30 November 2012

**North West Rail Link - State Significant Infrastructure & Systems  
(SSI\_5414)**

Thank you for your letter of 30 October 2012 inviting Council to comment on Stage 2 of the North West Rail Link (NWRL). Council officers have reviewed the documents provided and make the comments below. Please be aware that these comments have not been formally endorsed by Council.

Figure 10.8 Epping Services Facility and Receiver Areas

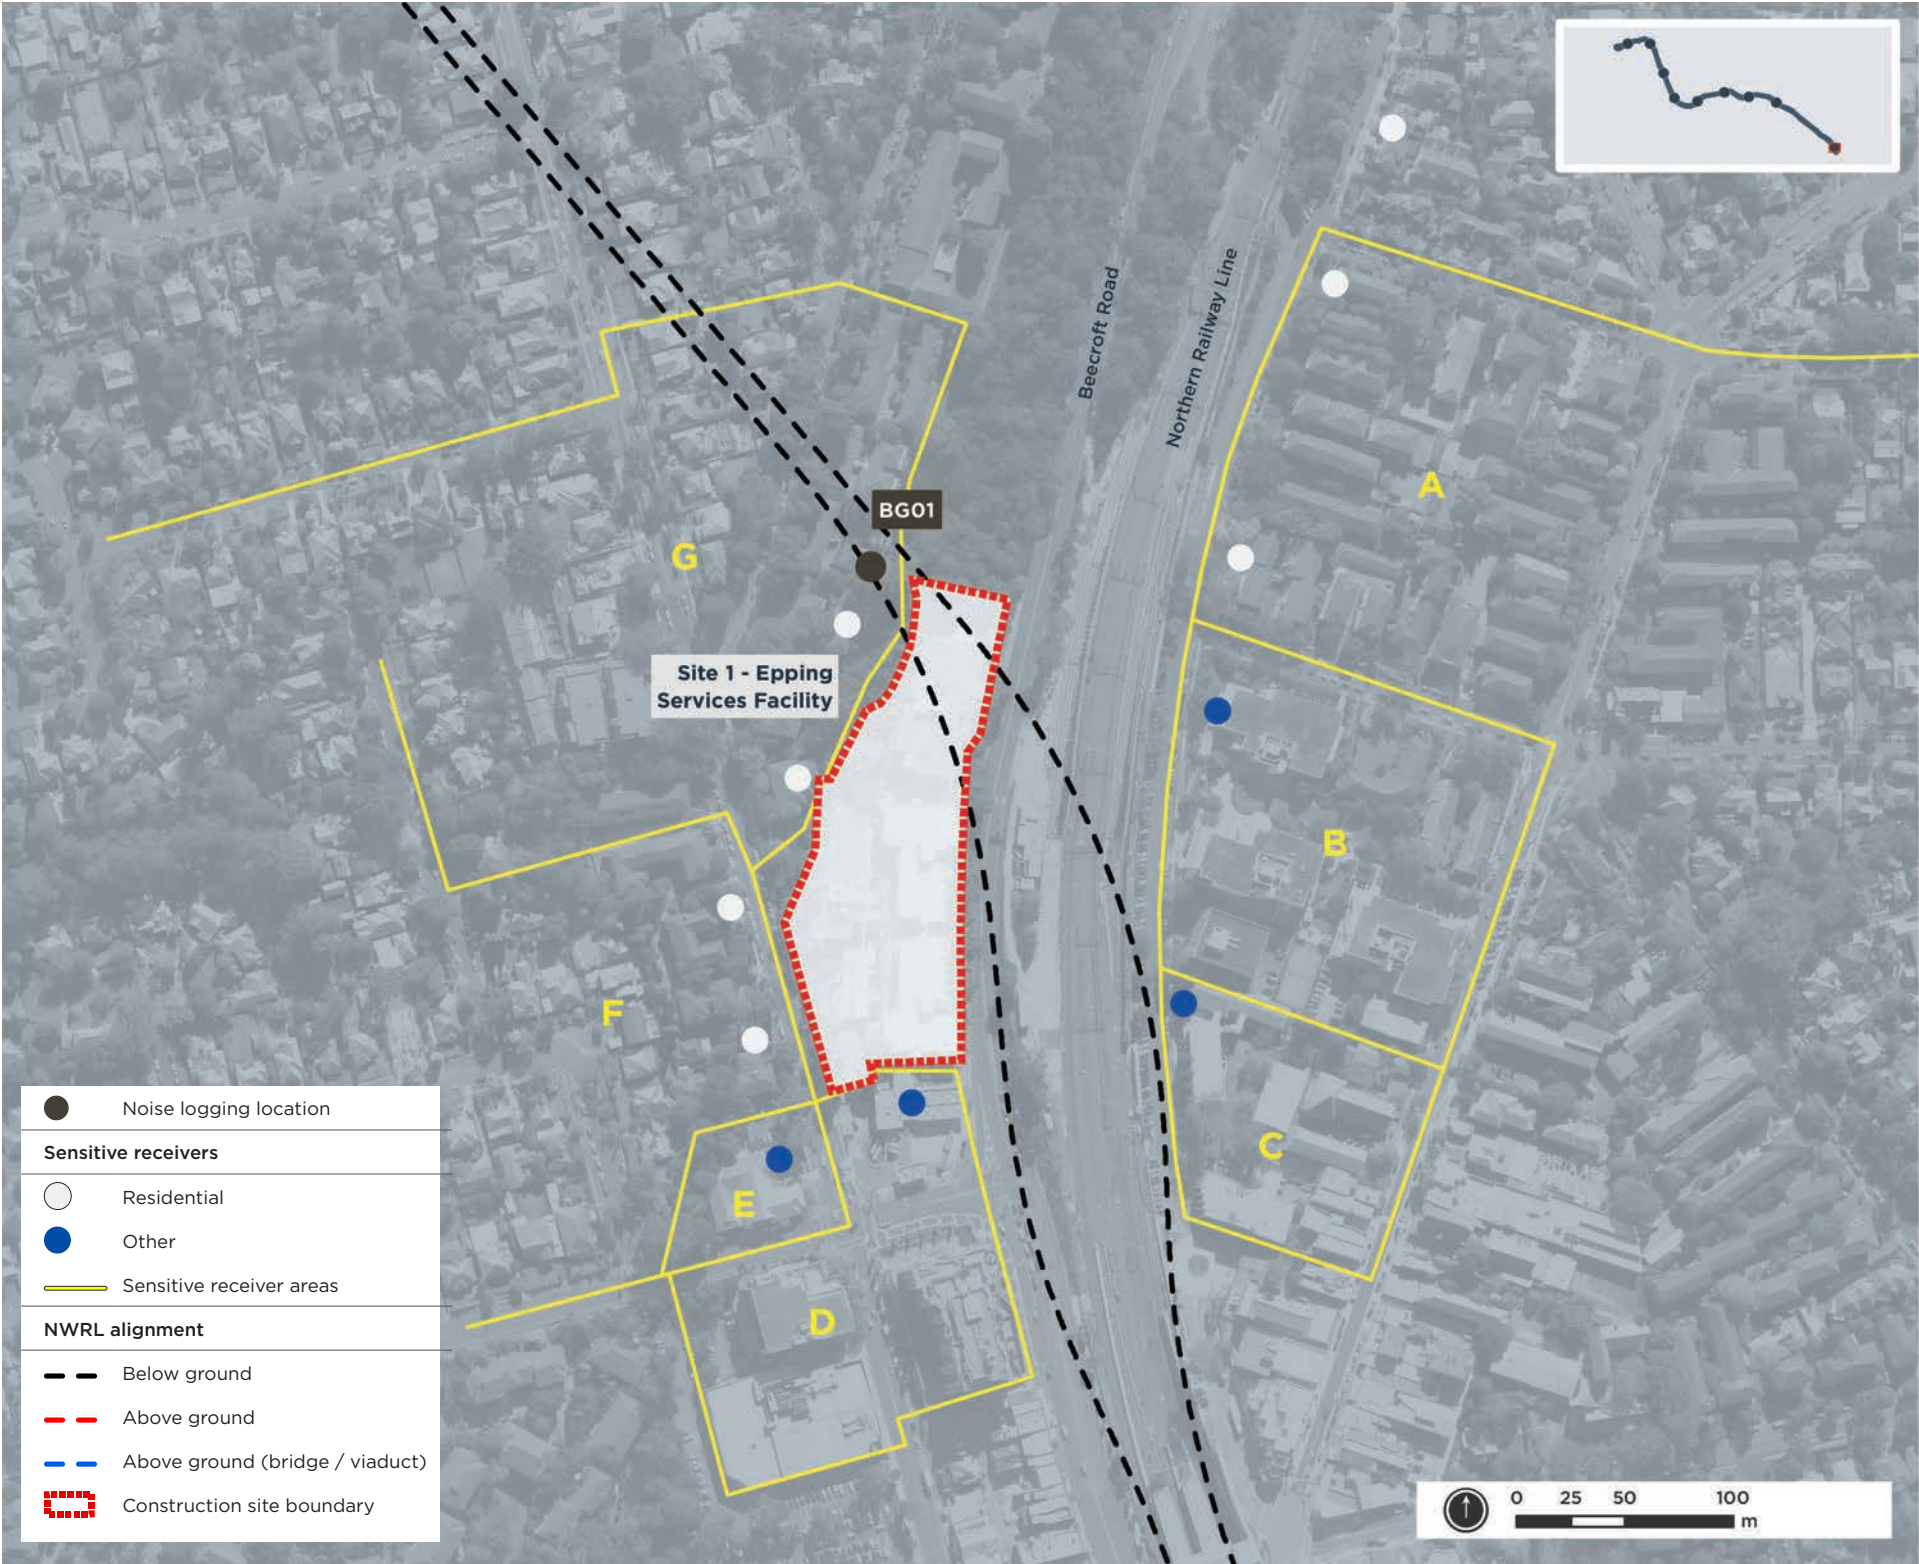
- In Table 10.9 and corresponding Figure 10.8, the area nominated as 'Area D' is identified as a 'commercial receiver'. It is noted that this is incorrect as the development on the southern corner of Beecroft Road and Carlingford Road comprises an existing mixed use residential and commercial development. Accordingly, the impact upon these existing residential units needs to be considered and should not exceed relevant noise level criteria for 'residential receivers' during construction and operation.

- a) Reassess impact on 'Area D' as a 'residential receiver'.
- b) Adoption of recommendations made by SLR Consulting during detailed design phase of the project in order to address noise and vibration impacts.
- c) Setting of performance-based noise and vibration specifications as part of the construction contract.
- d) Development of separate Noise and Vibration Management Plans for both the construction and operational phases of the NWRL.
